September 21, 2022

RE: Mack Townhomes - 1st Technical Review Comment Letter

Please refer to our responses below which address all review comments received from you via email on July 11, 2022. You will find the markup comments listed in the order that they were written followed by our response in *italics*.

**TEC HOLDINGS 123, LLC**  
**MACK TOWNHOMES**  
 EXISTING CONDITIONS MAP

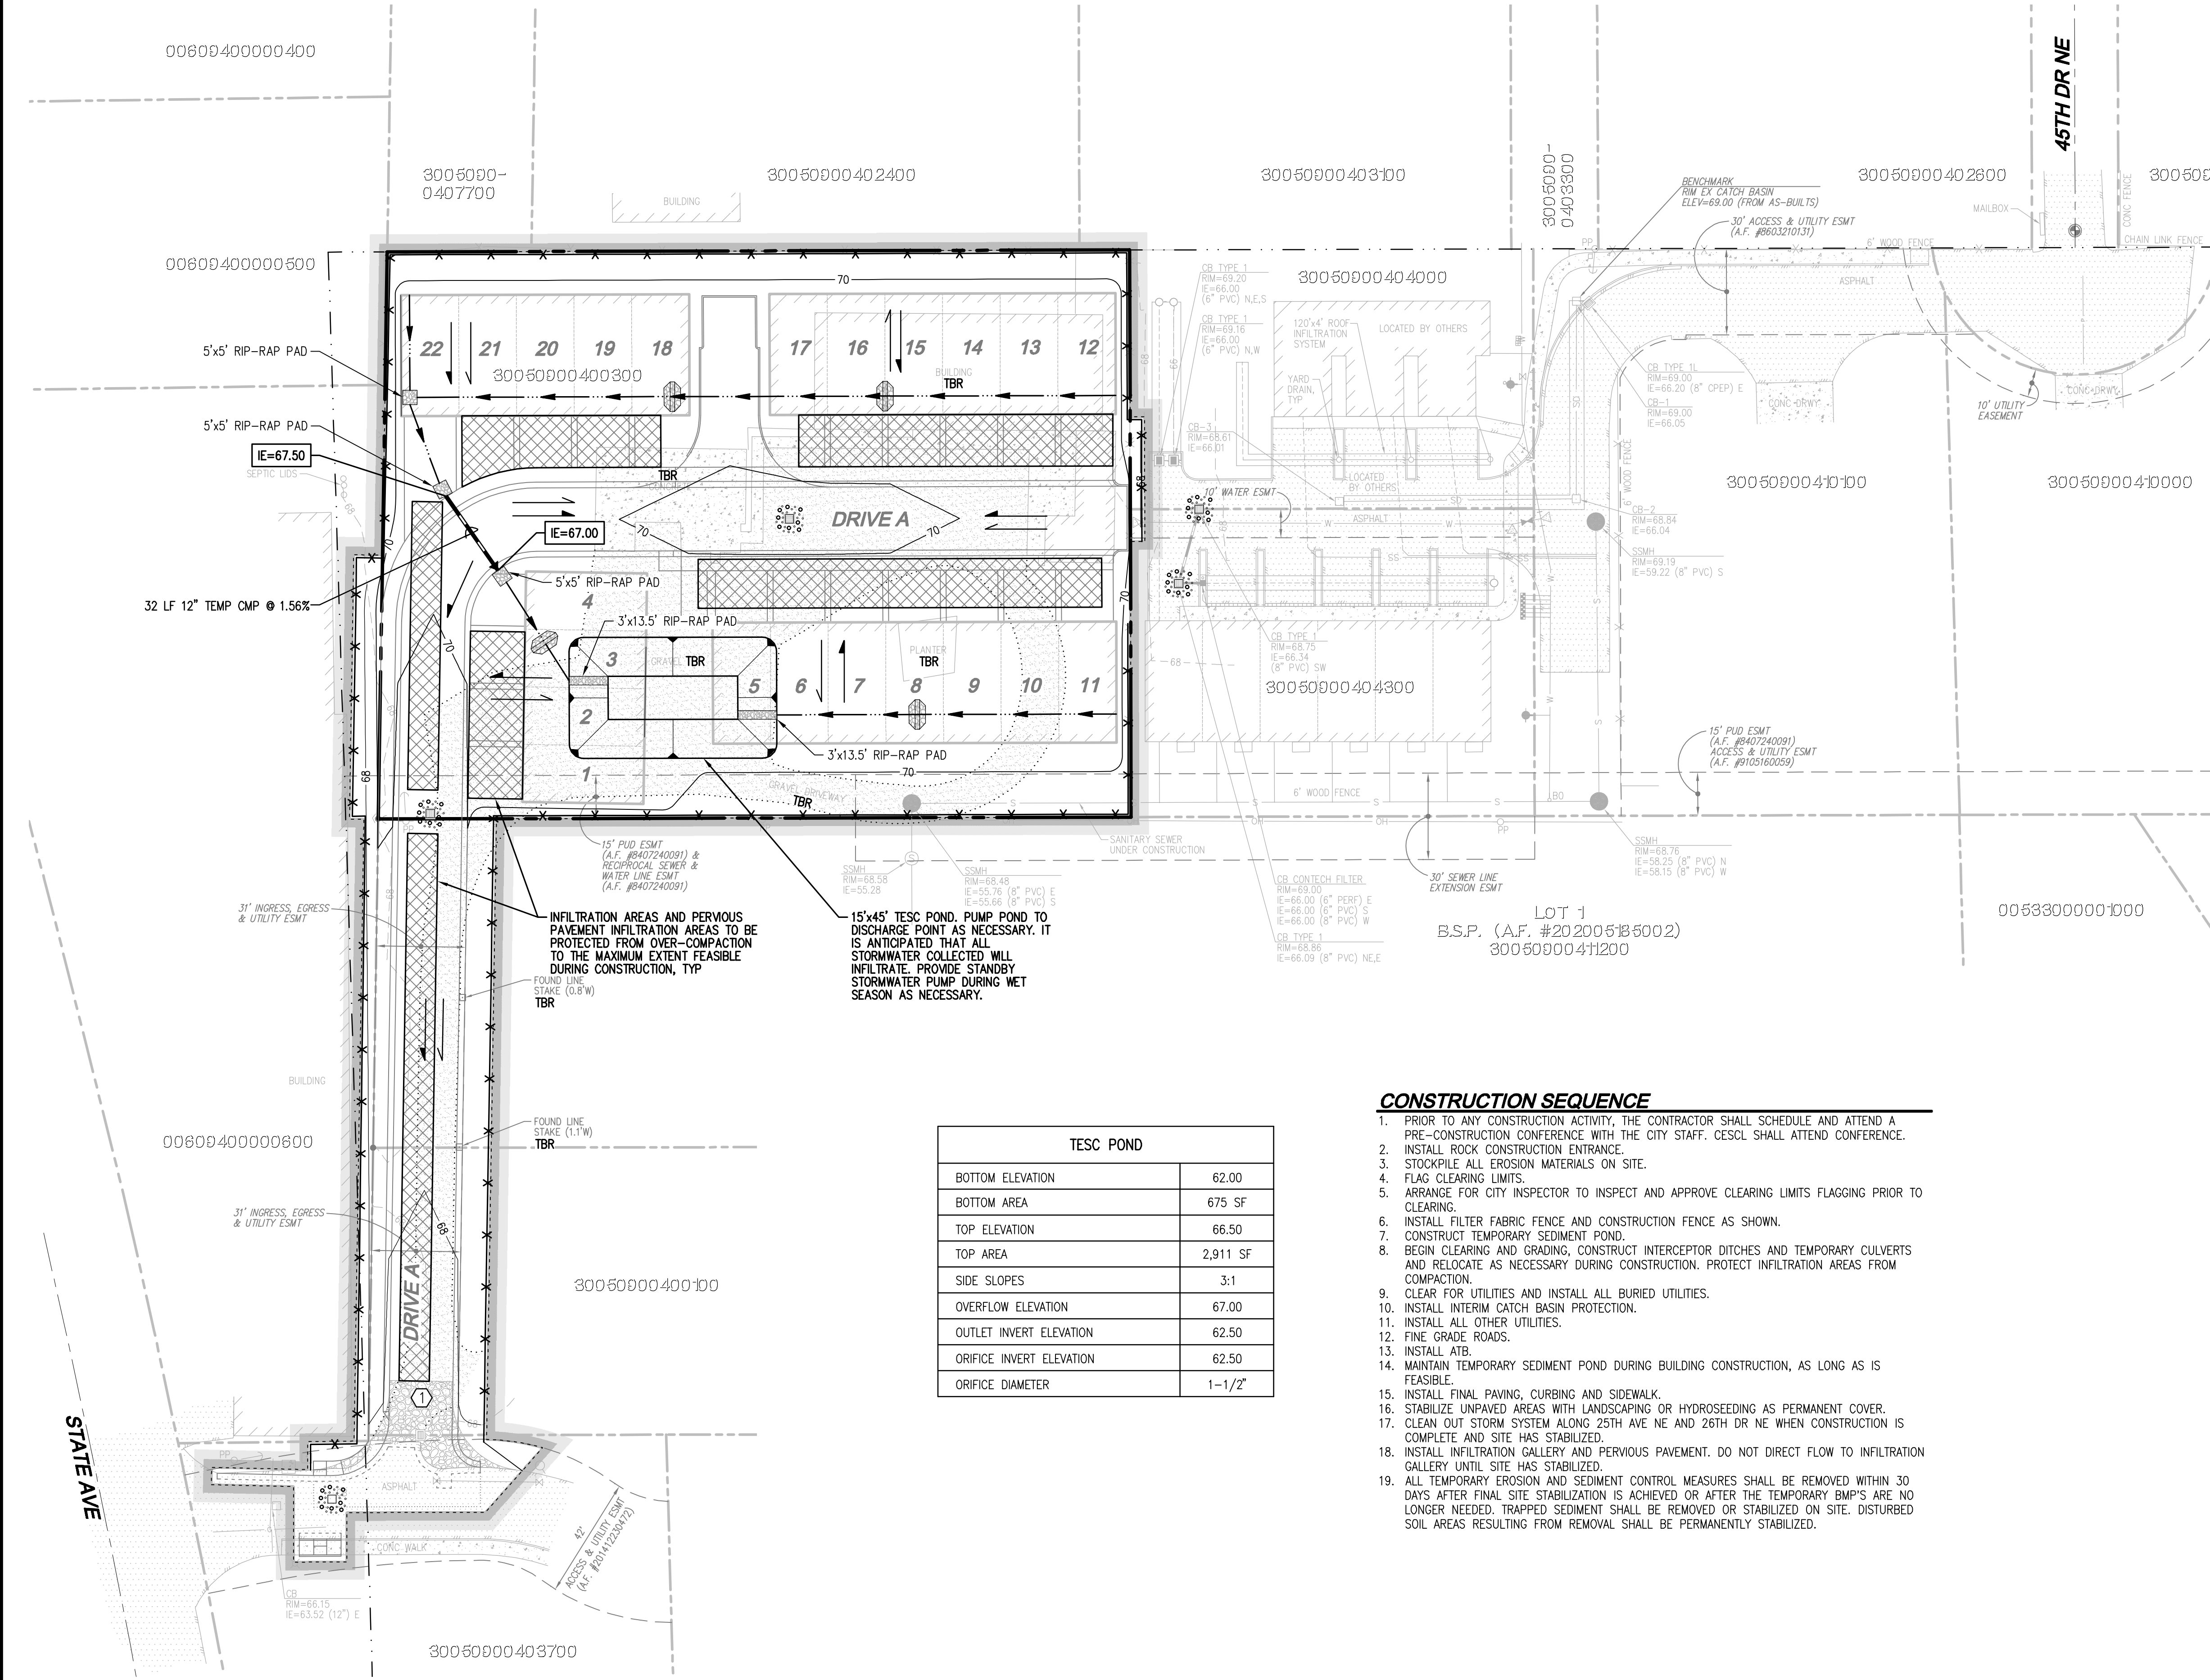
2. Please identify the AFN for the access easement on parcel 3005000041120.

Response: The AFN reference 202205310569 has been added to the survey sheet TO-01.

TEC HOLDINGS 123, LLC  
**MACK TOWNHOMES**  
 PRELIMINARY SITE PLAN

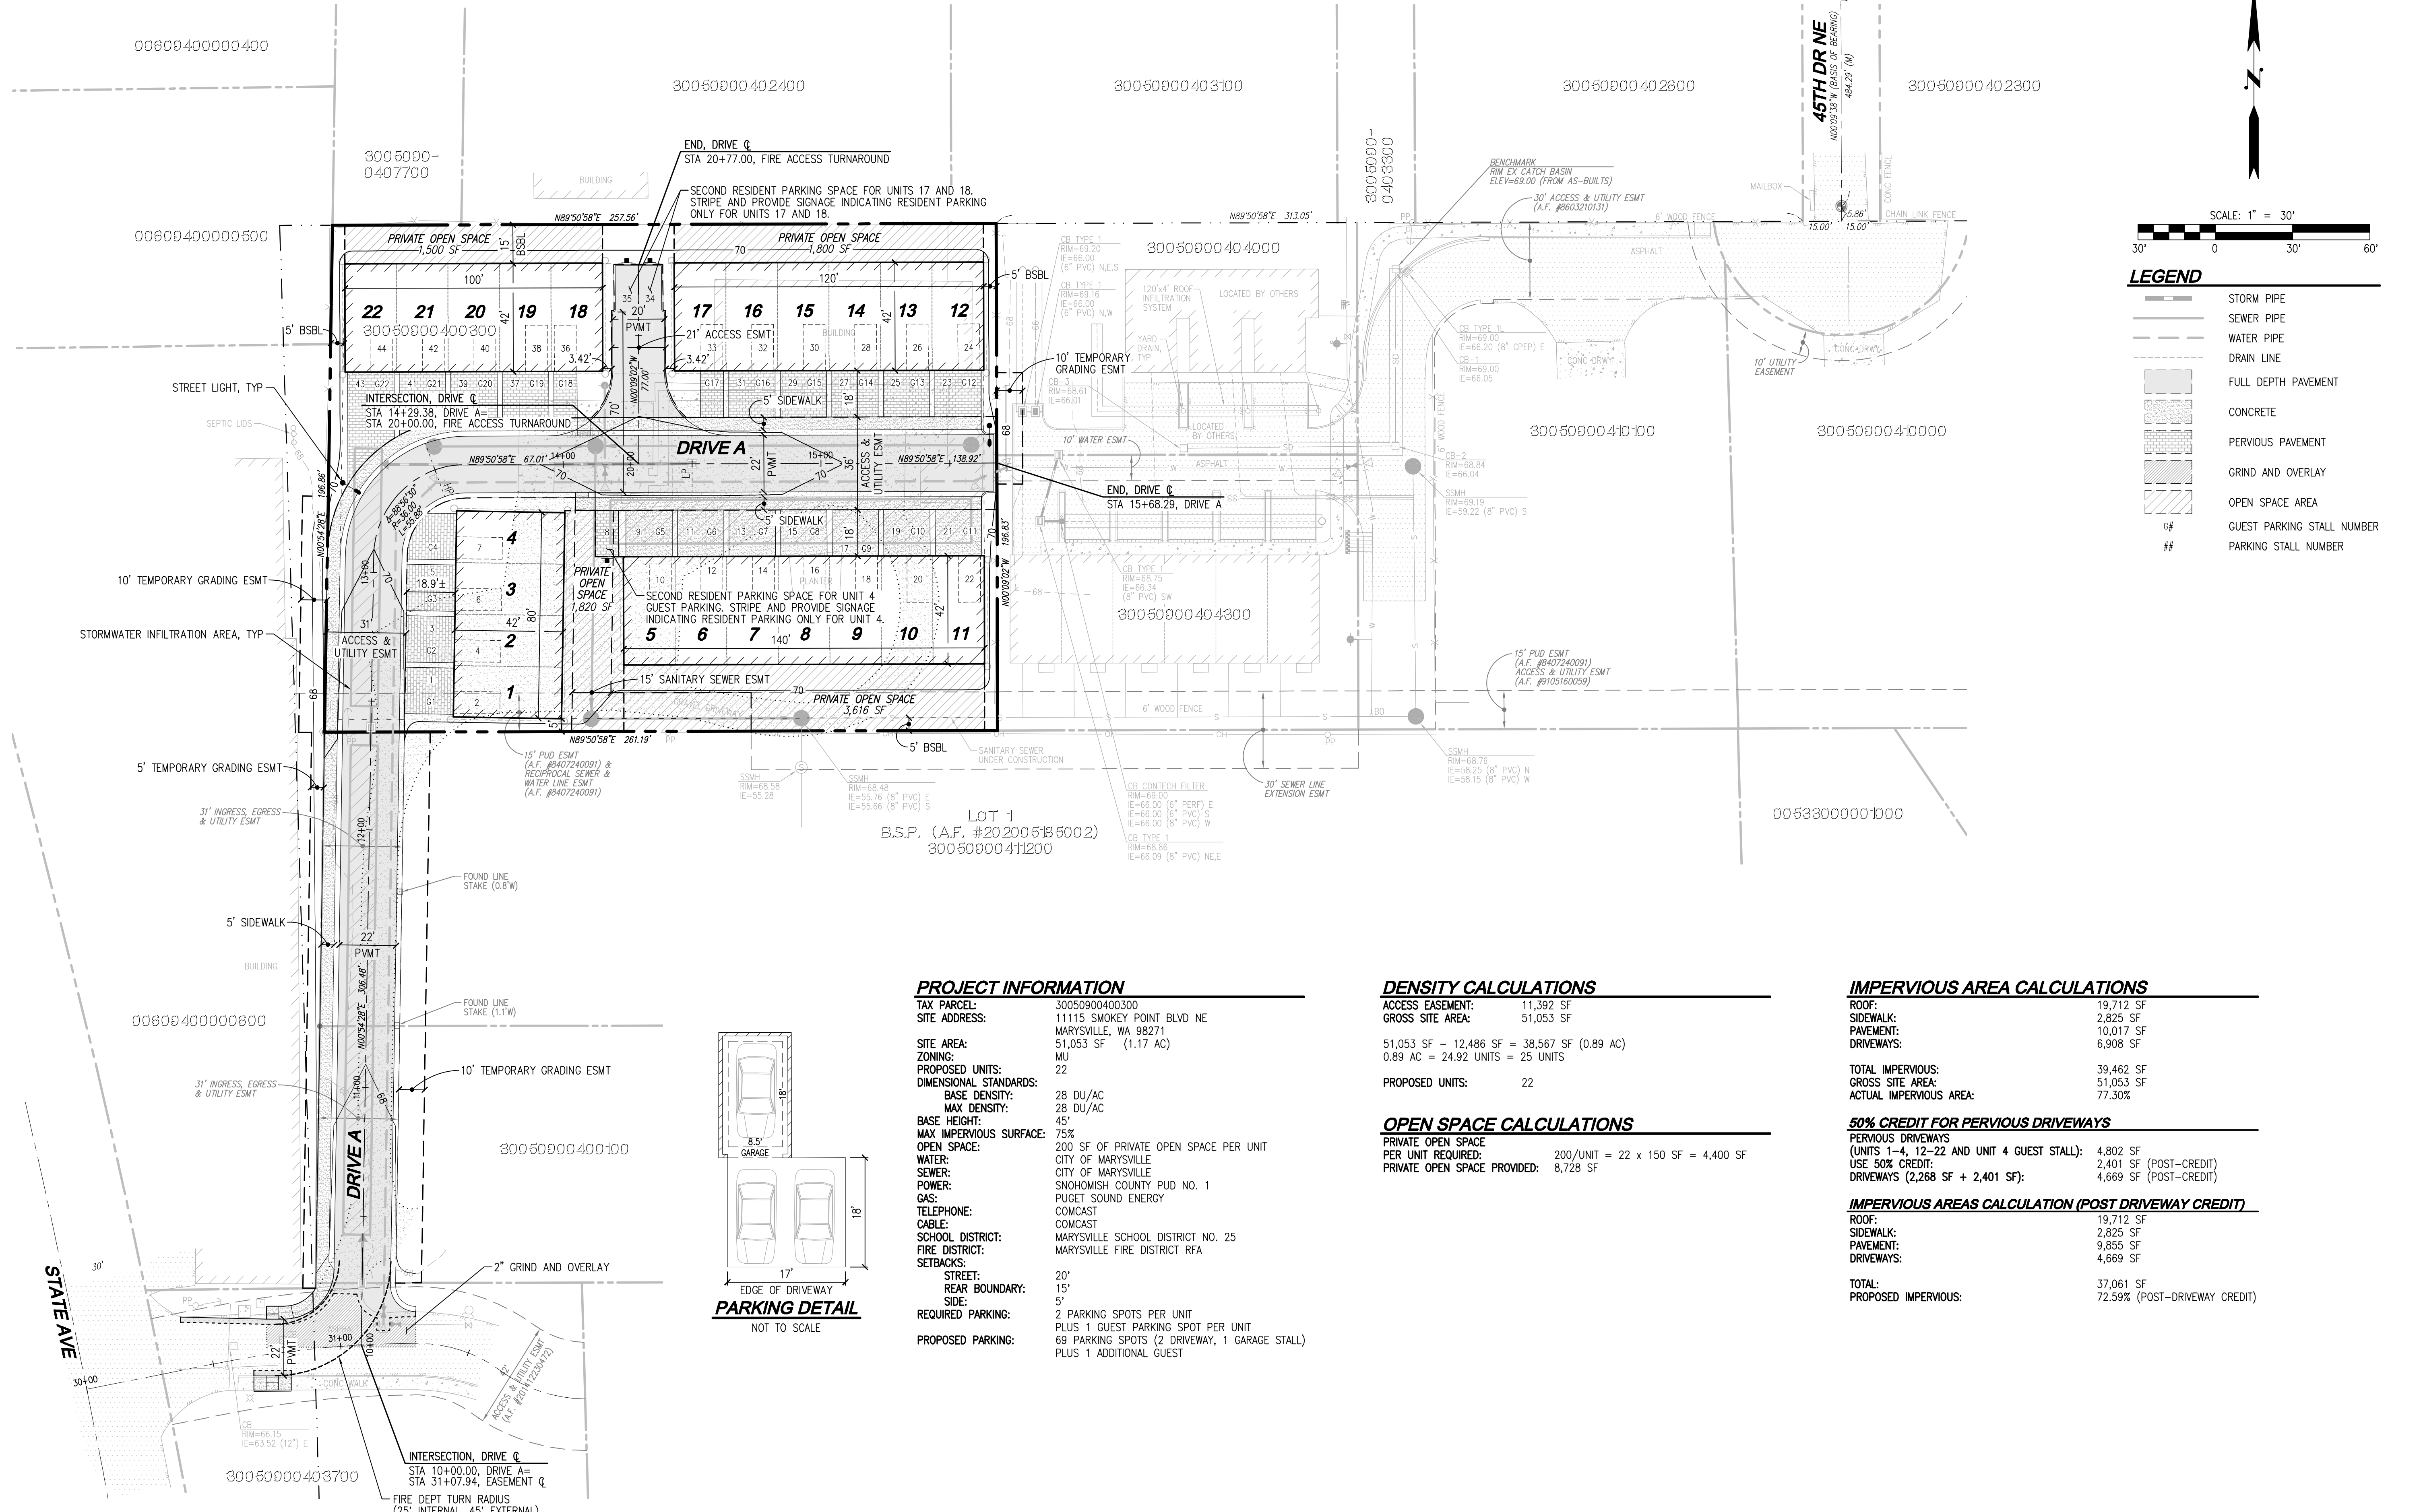
3. The maximum allowed impervious surface coverage for the Zoning designation is 85%.

Response: Noted. The project proposes approximately 73% coverage. See impervious coverage calculations on sheet SP-01.

TEC HOLDINGS 123, LLC  
**MACK TOWNHOMES**  
PRELIMINARY ROAD, STORM DRAINAGE AND GRADING PLAN

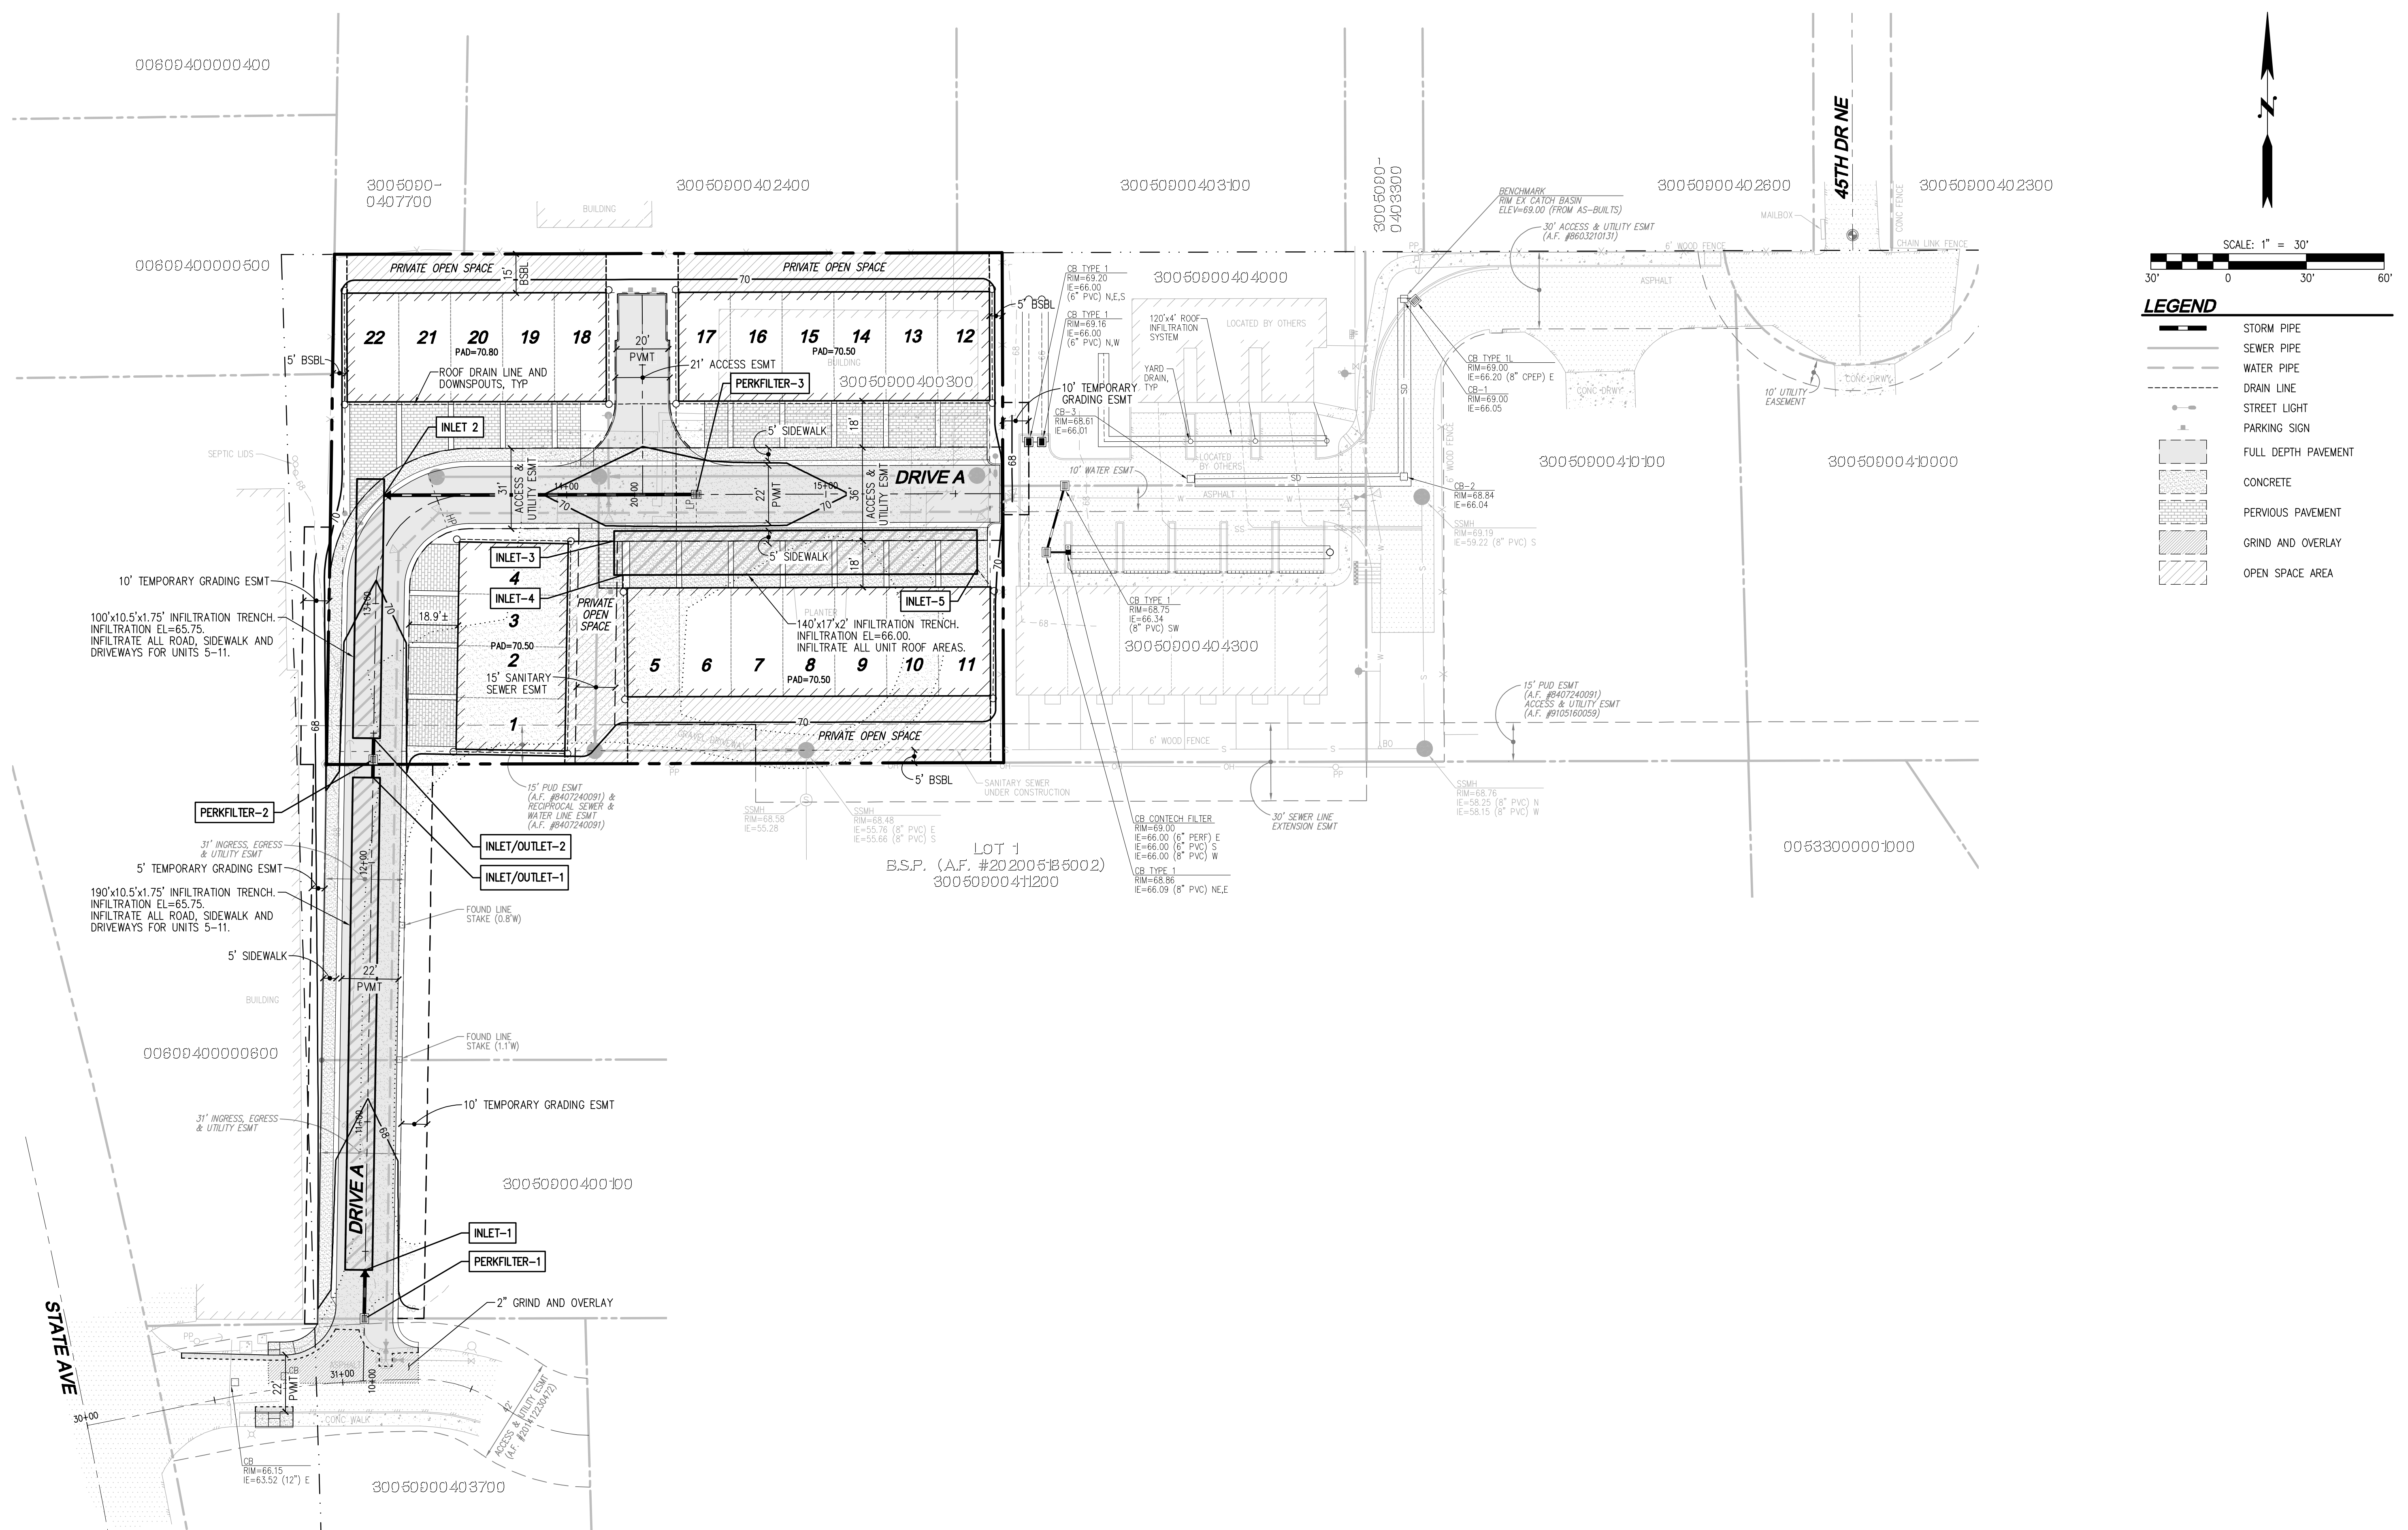
- b. As the project is constructing a private drive, an emergency vehicle turnaround can be allowed versus a cul-de-sac. See standard plan 3-207-004 of the EDDS for the hammerhead design which will need to be constructed on the east end of the project. The design that is shown does not meet the standard.

Response: The fire turnaround has been updated to meet the EDDS standard.
